**From:** [REDACTED]@forestrycommission.gov.uk>  
**Sent:** 19 January 2024 14:54  
**To:** Cambridge Waste Water Treatment Plant Relocation  
**Cc:** Kathryn Taylor  
**Subject:** WW01003 - Cambridge Waste Water Treatment Plant Relocation

We have discussed the veteran trees identified in document APP-057 and mentioned in Inspectors question (14.11) between Clayhithe and Horningsea during a meeting with Anglian Water.

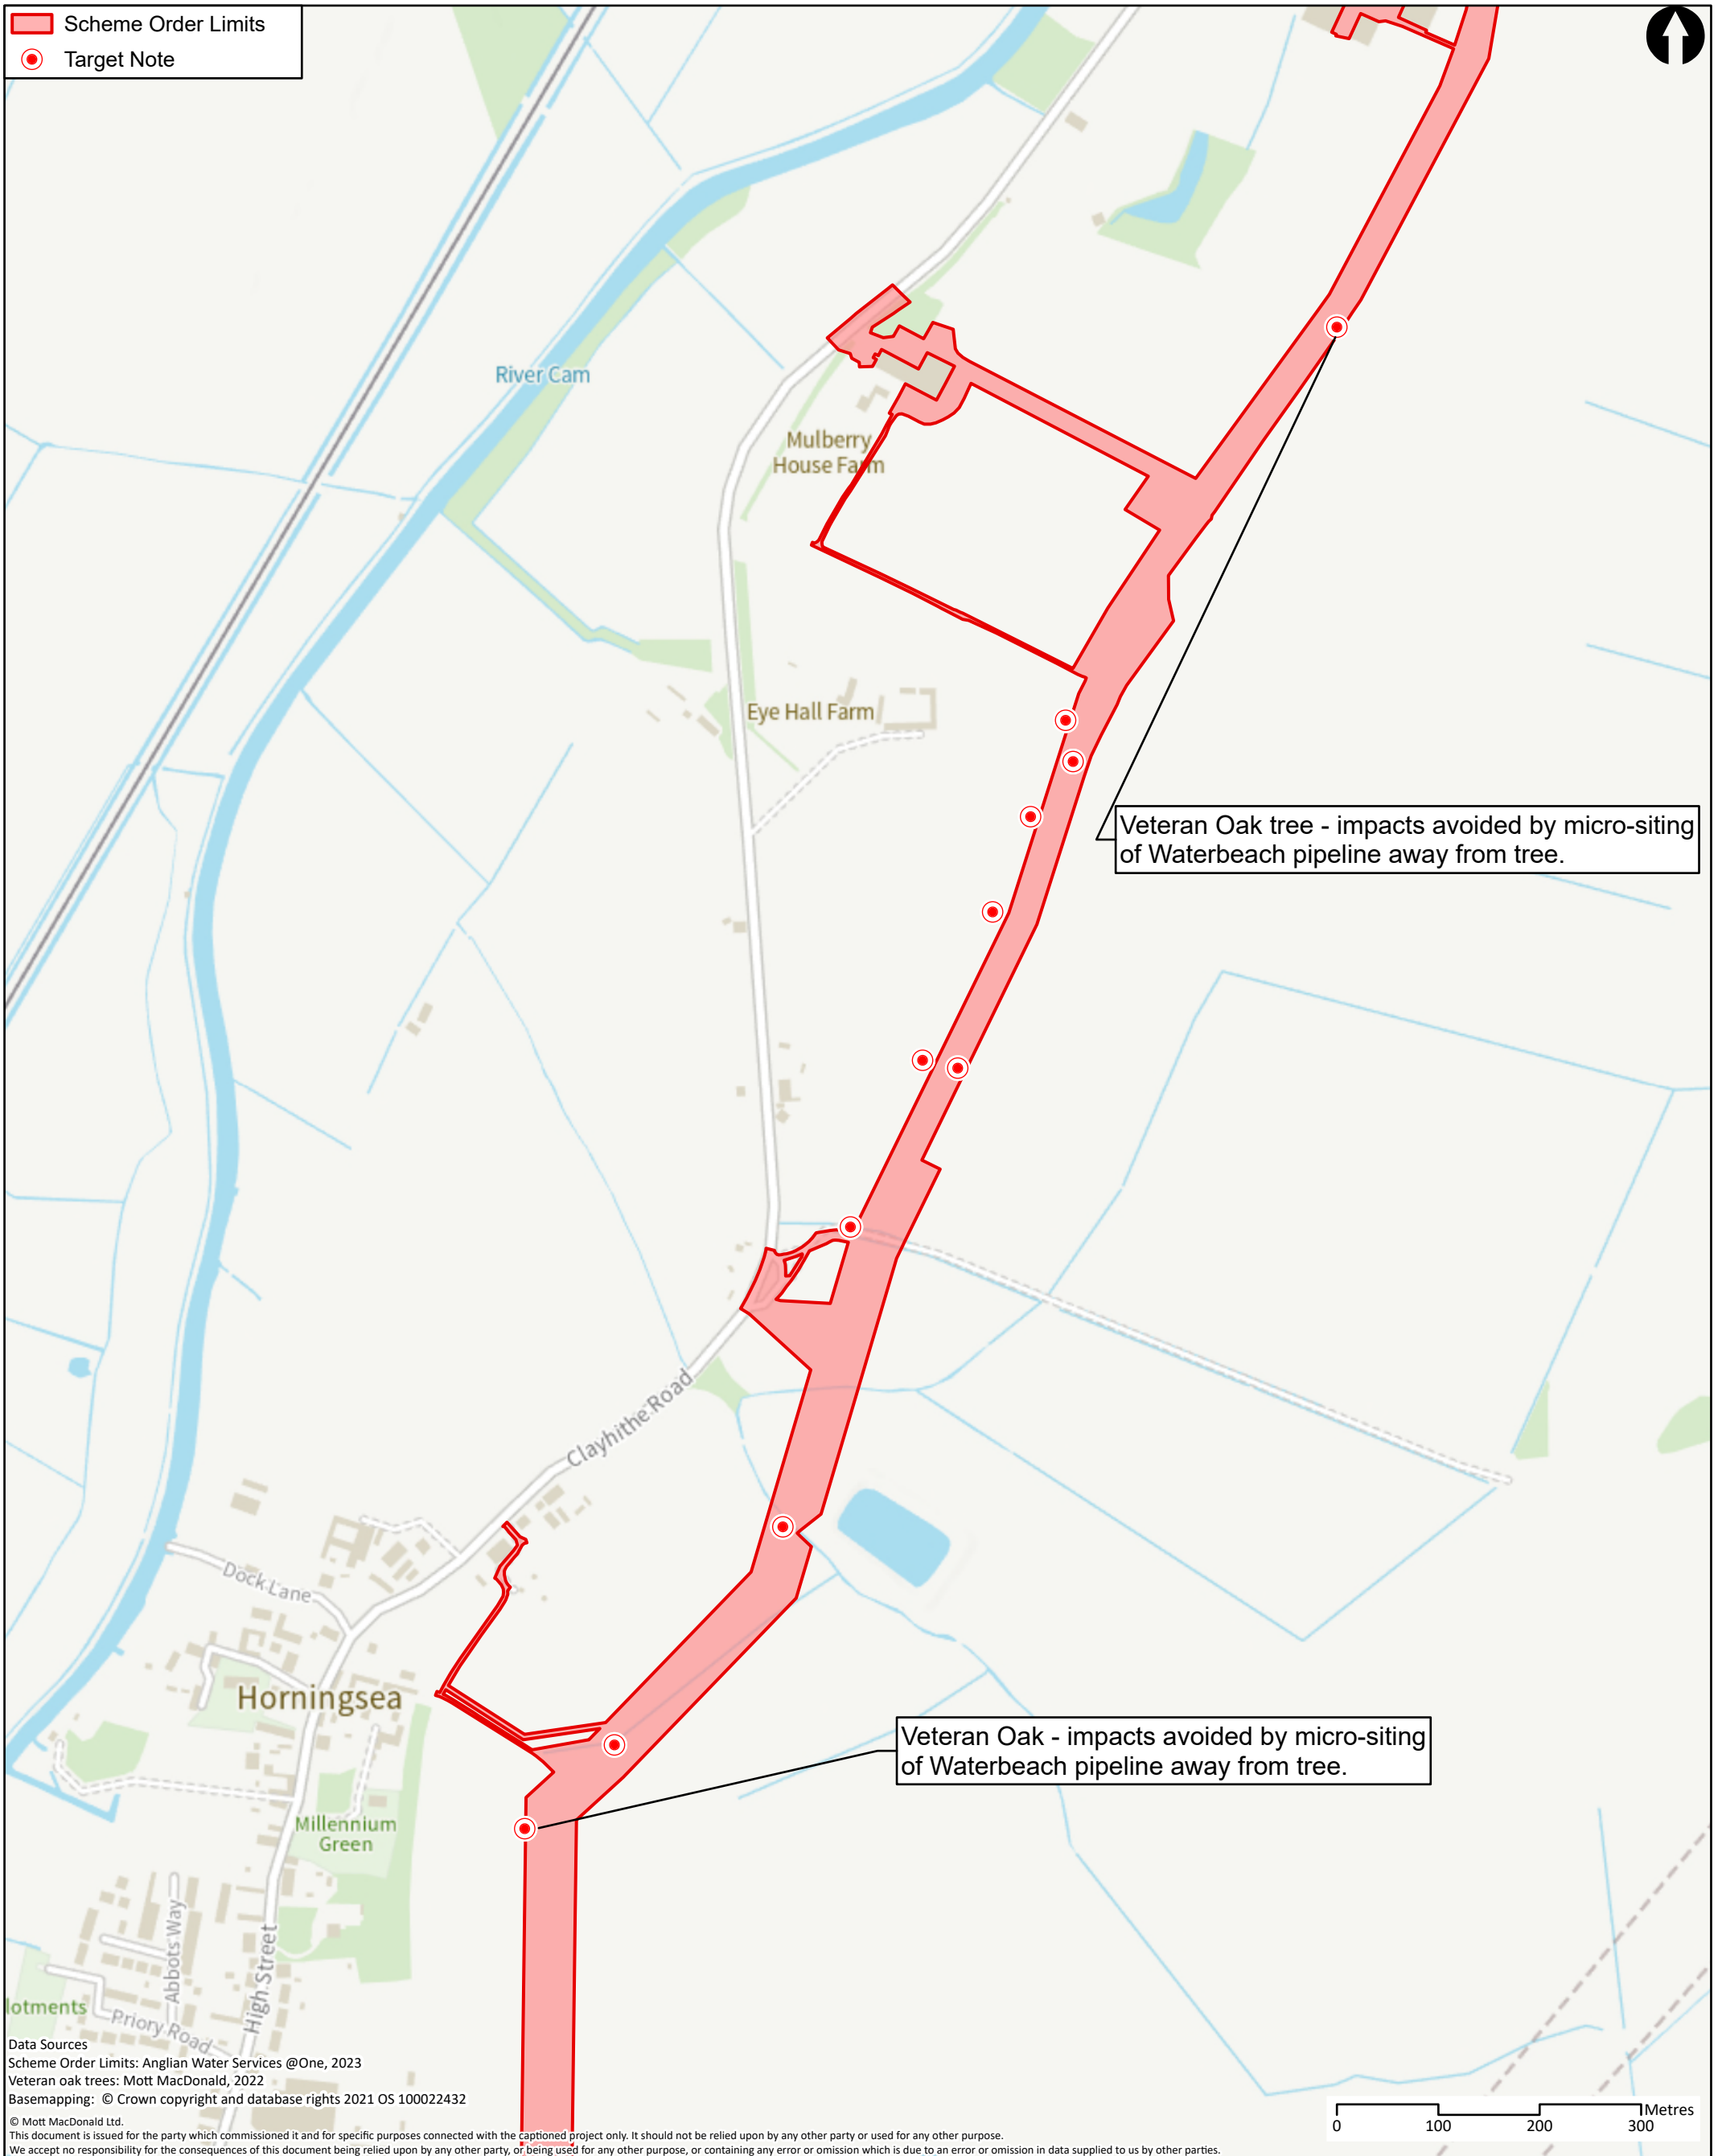
We have reviewed the updated arboricultural impact assessment report, with the increased root protection area of at least 16m for Tree 105 and are satisfied that will provide sufficient protection for the roots during development. We are to understand the other veteran tree in the report was mistakenly identified as a veteran tree therefore the usual RPA will suffice.
